# CITY OF ALBUQUERQUE

**Re: Walgreens (SWC) San Pedro & Paseo del Norte, 6200 Paseo Del Norte NE  
Drainage and Grading Plan - Engineer's Stamp dated 02-15-05 (D18-D14A)**

Based upon the information provided in your submittal dated 01-04-05, the above referenced report is approved for Rough Grading. Prior to Building Permit approval, please address the following comments:

DRAINAGE MANAGEMENT PLAN

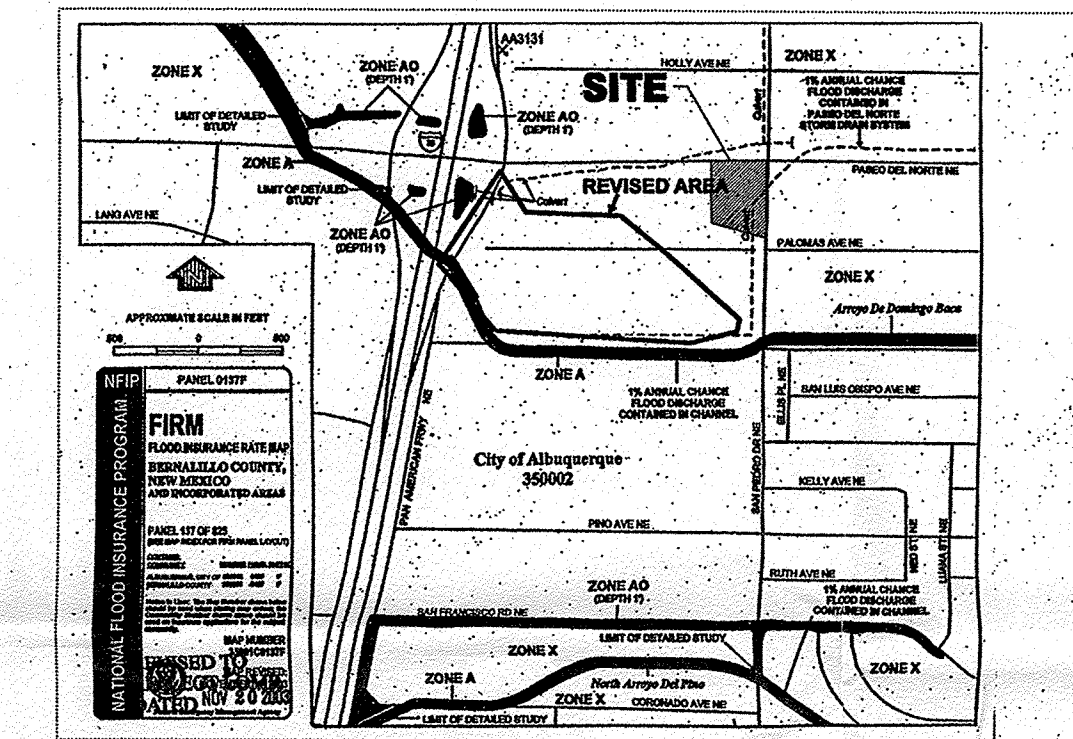
- Clarify where the new storm drain inlet located in Basin P2 will discharge. The Drainage Management Plan states that it will discharge into the existing storm drain located at the southwest corner of the site, which is in conflict with the note that states to remove the existing storm drain, inlet and headwall.
- Verify that the proposed retaining wall at the southeast corner of the site does not conflict with the existing storm drain trench prism.
